### PLANNING APPLICATION CONSULTATION RESPONSE

<b>Application Number:</b>	3/2022/0096
<b>Proposal:</b>	Demolition of former calf building, offices and retail units and construction of new building split into two units
<b>Location:</b>	Gisburn Auction Market, Gisburn, Lancashire

#### **Lead Local Flood Authority Position**

The Lead Local Flood Authority **maintains its objection** to the above application on the basis of:

GISBURN AUCTION MART	
Project: PROPOSED INDUSTRIAL DEVELOPMENT AT GISBURN AUCTION MART LTD GISBURN	
Title: PROPOSED DRAINAGE STRATEGY	
Rev: A1	AS SHOWN
Rev: IB	PMc
JUN 22	
PRELIMINARY	
Job Number: 22045 - PWA - 00 - XX - DR - C - 1001	Rev: P01

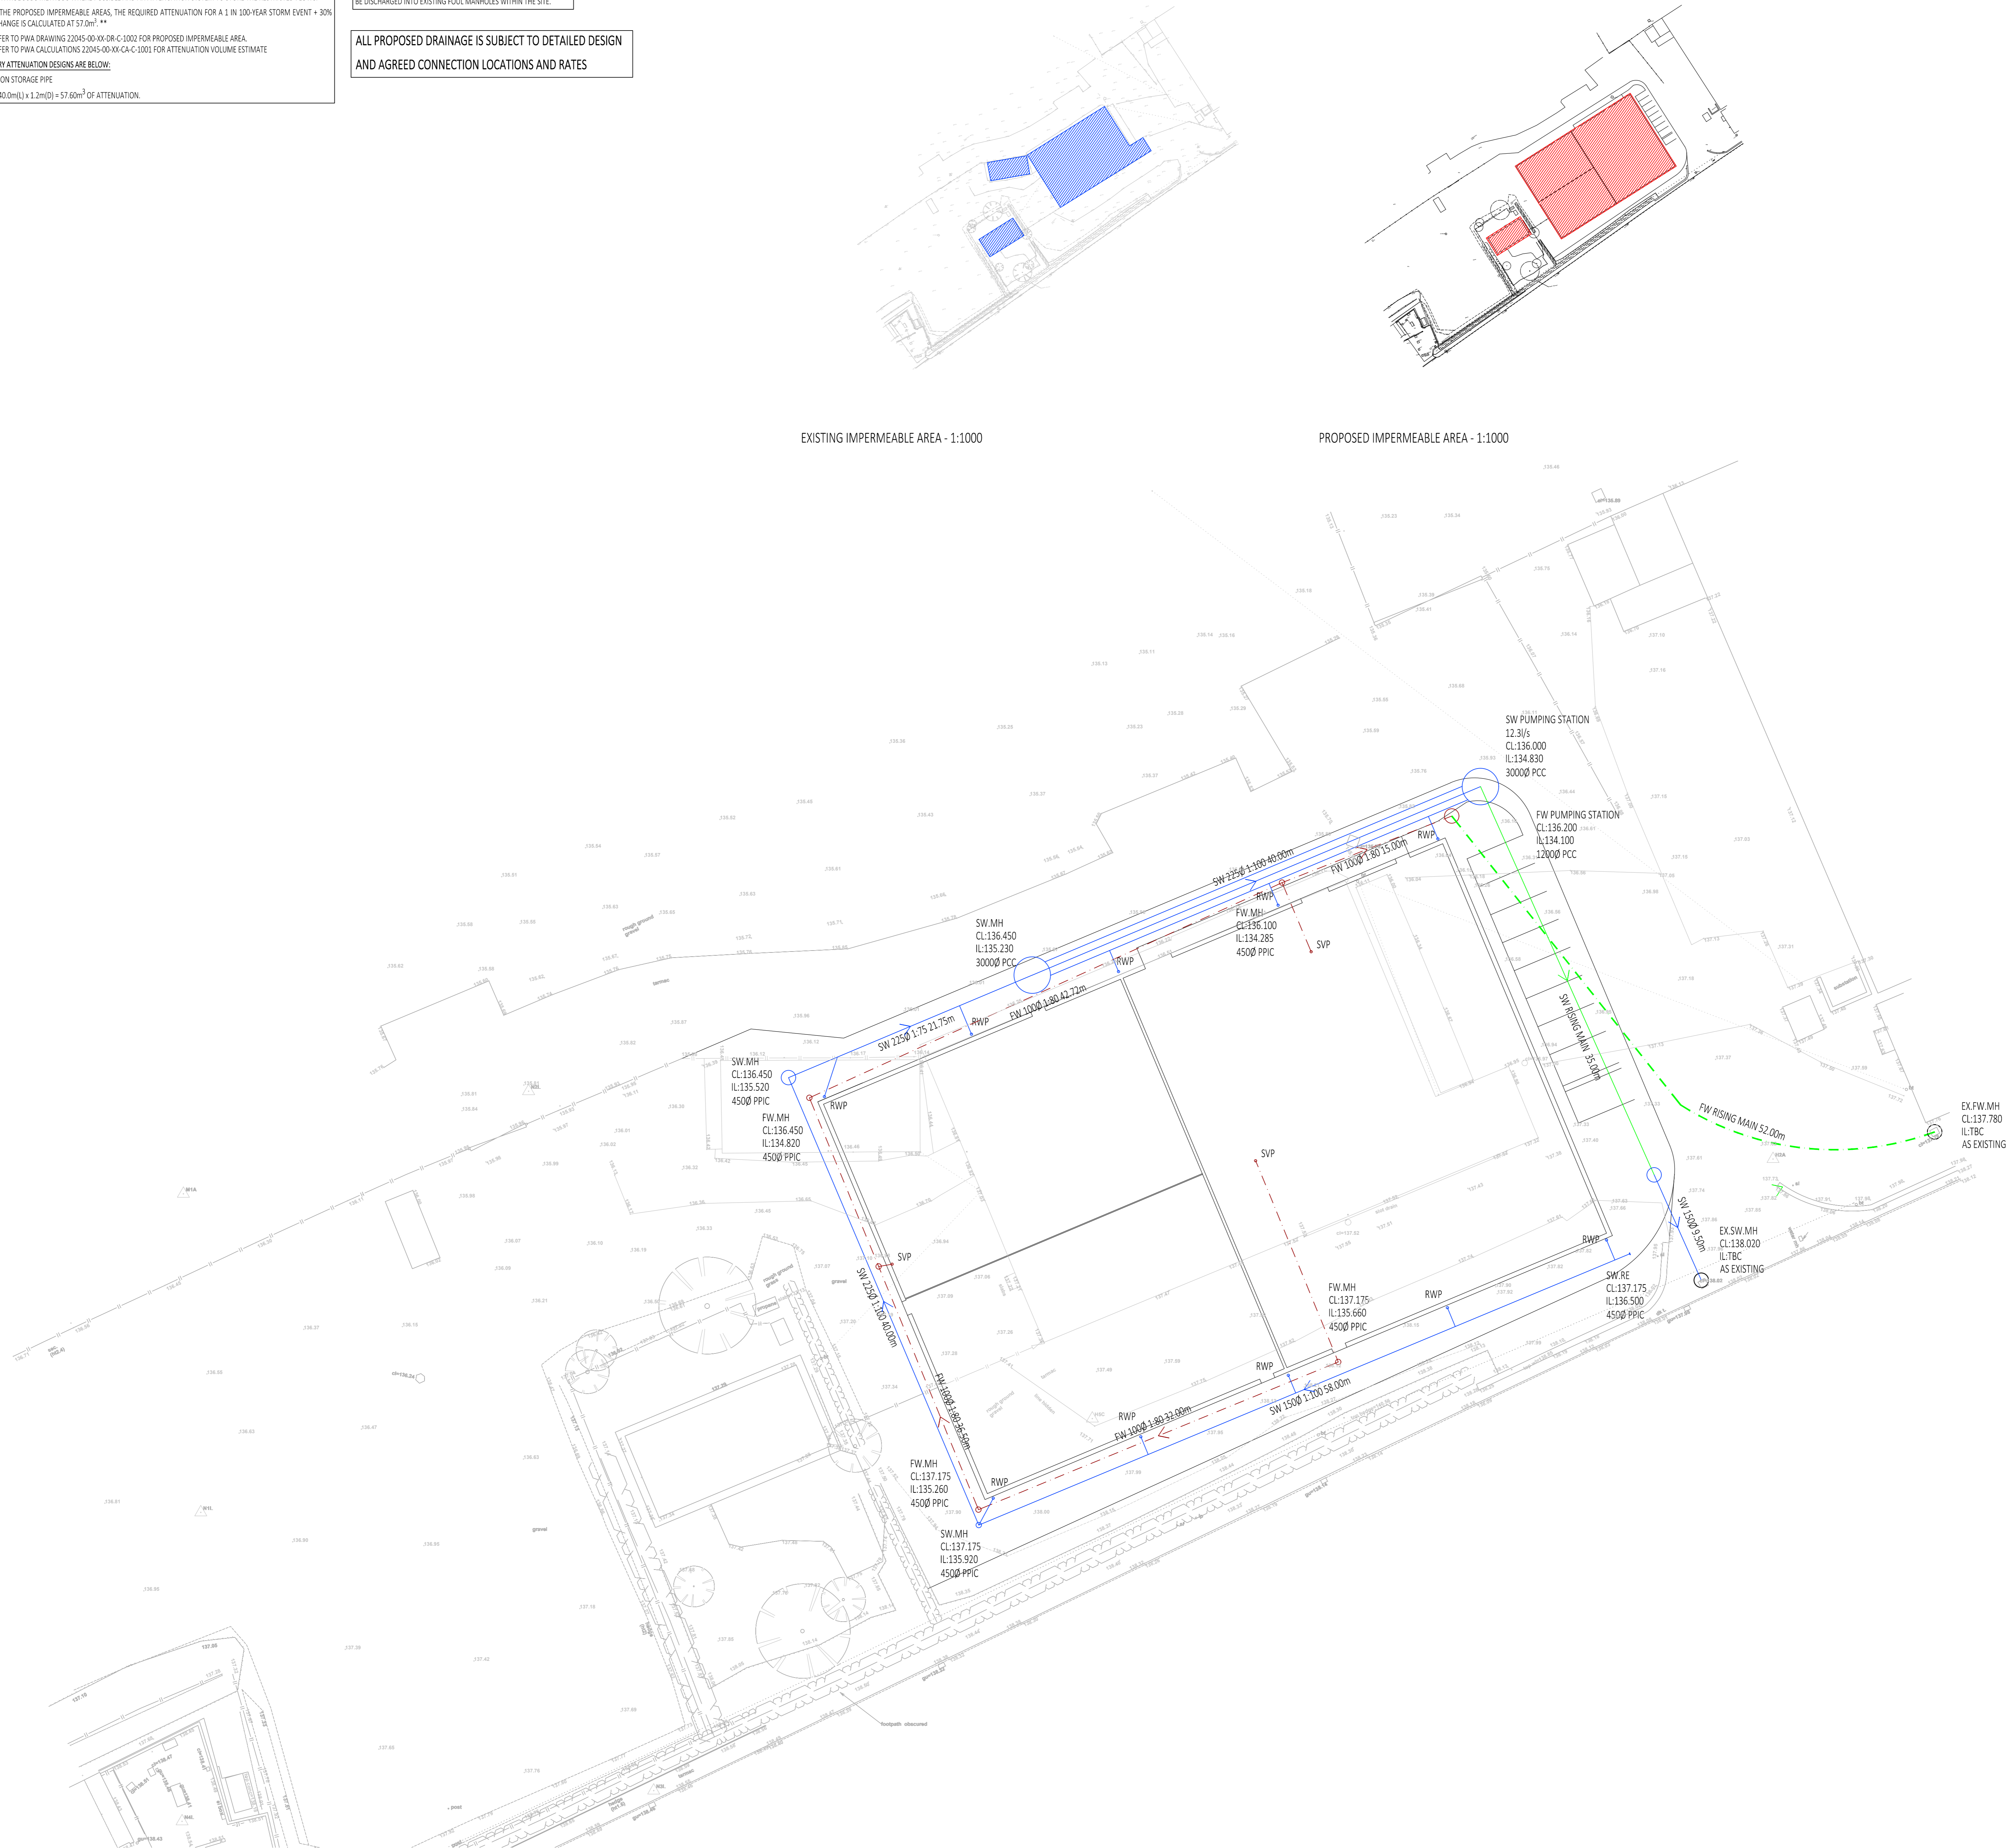
- The applicant has failed to provide a drainage strategy as outlined in the Lead Local Flood Authorities previous response.
- The Lead Local Flood Authority recognises that the applicant has provided an indicative drainage layout, however this does not in itself fulfil all the evidence that would be present in a drainage strategy, for example evidence of the drainage hierarchy options and an explanation for the option chosen, evidence of drainage calculations and rates applied to the development. For the

avoidance of doubt the applicant can refer to the North West SuDS Pro-forma which outlines what information is expected in a Drainage Strategy.
